In reply please quote: 09/05306
Your Ref: SSD 5248

27 May 2014

GAZCORP INDUSTRIAL ESTATE – 813-819 WALLGROVE ROAD, HORSLEY PARK (SSD 5248)

**DRAWING TITLE**  
**MASTER PLAN**

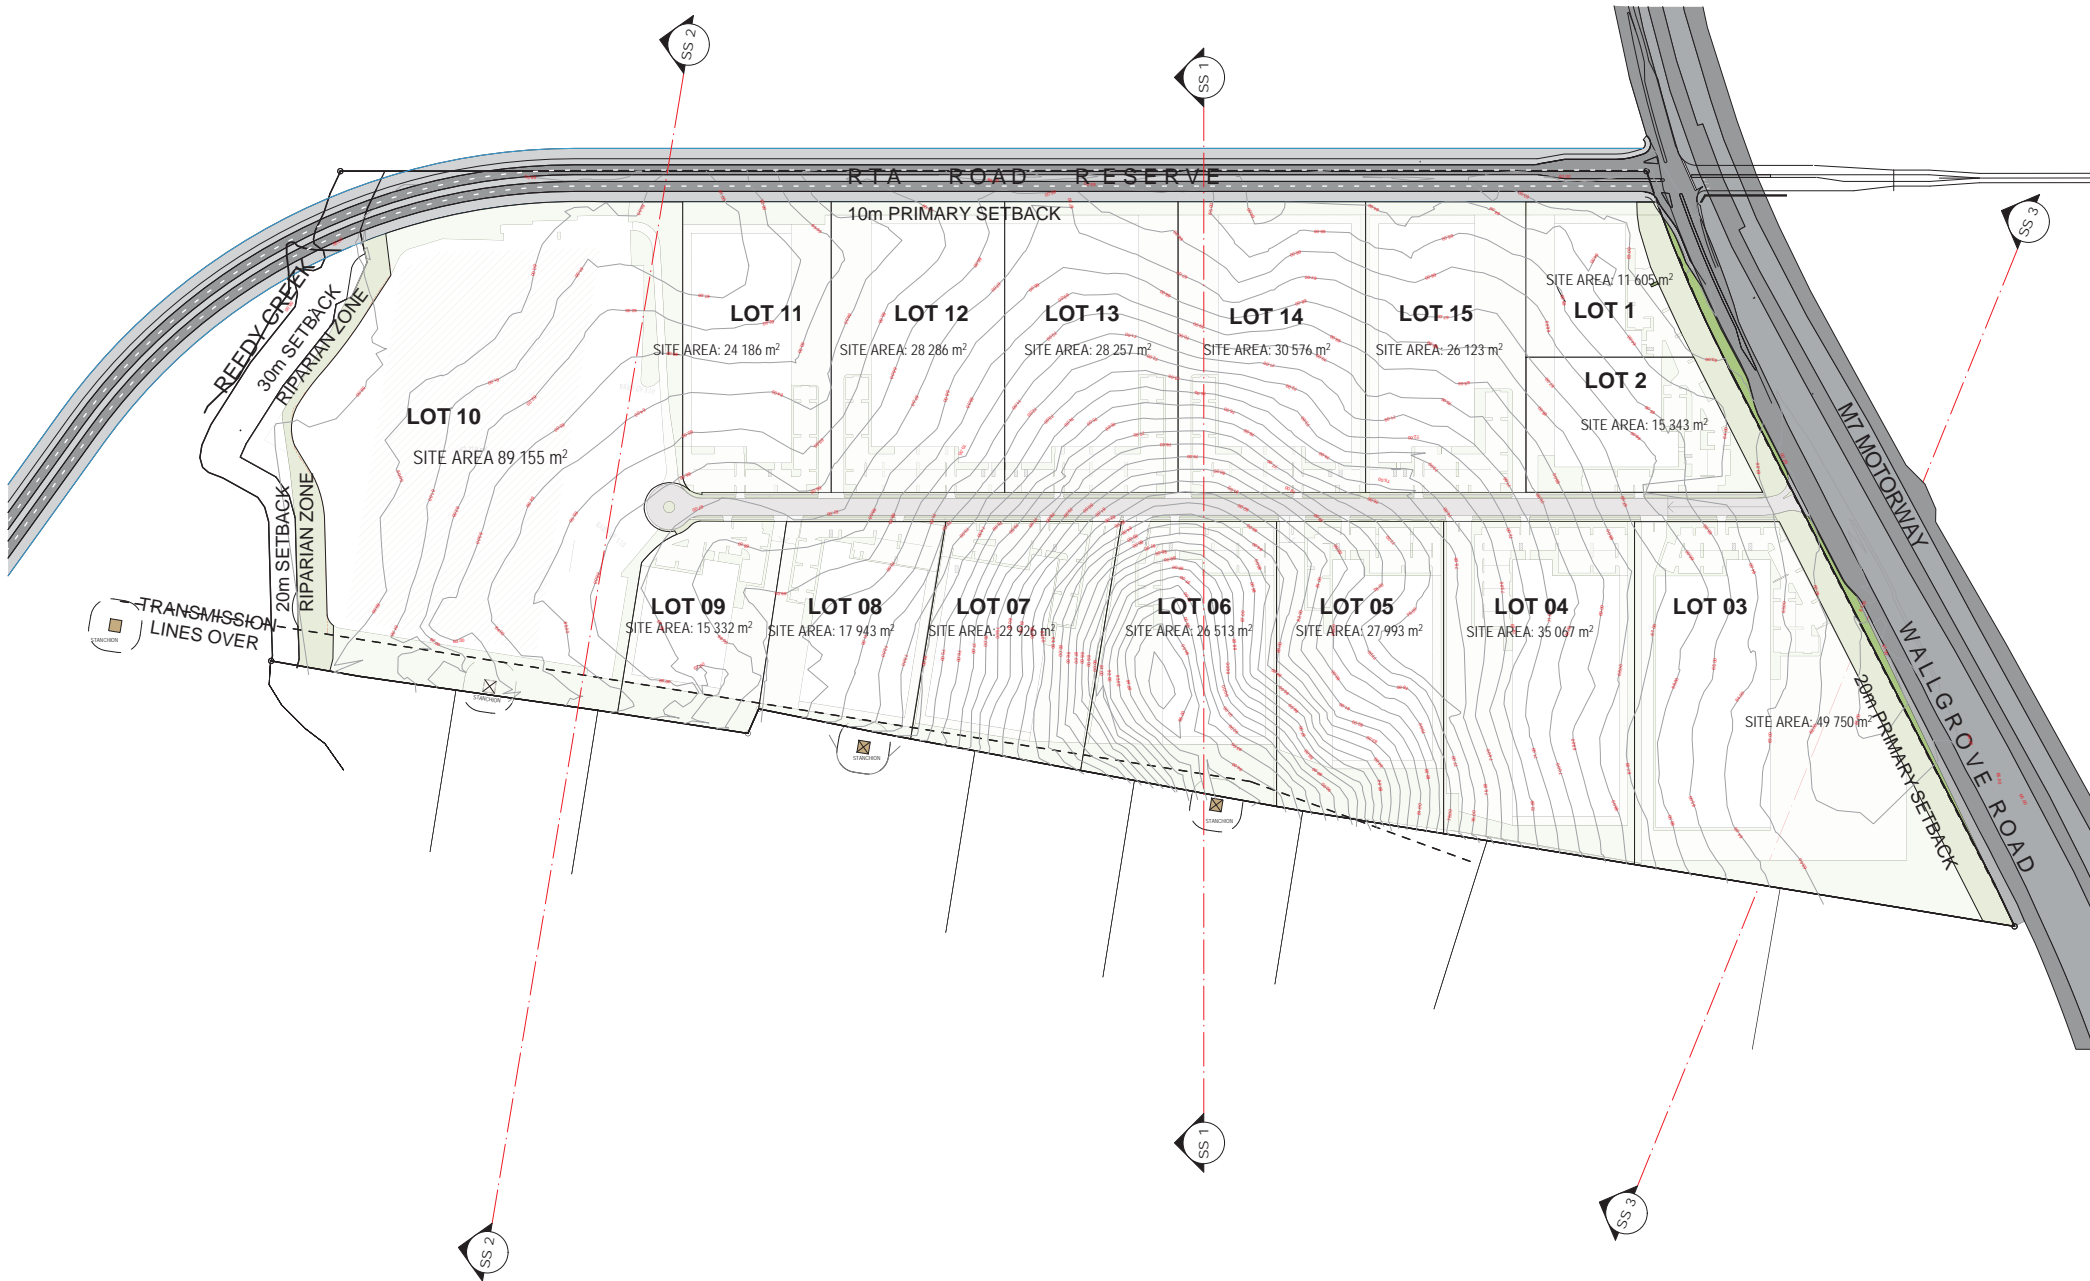
Notwithstanding the above, Council supports the objections of adjoining residential properties and fully supports their request that additional investigations and measures be included in the development (including provision of a mound and masonry wall rather than a colourbond fence) to maximise measures to safeguard the acoustic amenity of residents.

At this stage, Council does not propose to nominate a specific height for a masonry wall, as this needs to take into account the overall height of the proposed mound, which requires further investigations and consultation with residents. Potential designs for the mounding and noise barrier would be one the key issues that needs to be explored at the community meeting involving the applicant, local residents and officers from the Department.

Notwithstanding, it will be necessary to investigate increased setbacks and buffer areas to industrial uses on the Gazcorp site to that currently proposed (ranging from 10-40m) to provide a suitable landscape mound and mitigate acoustic, visual and lighting impacts on adjoining rural residential properties in Fairfield City.

In this regard, the measures requested by the residents (including provision of a landscaped mound and masonry wall) are supported as this will help to mitigate the visual impacts on the proposal on surrounding rural residential development, particularly at the eastern and western ends of the development and are required to ensure the proposal complies with the above requirements of the SEPP (WSEA).
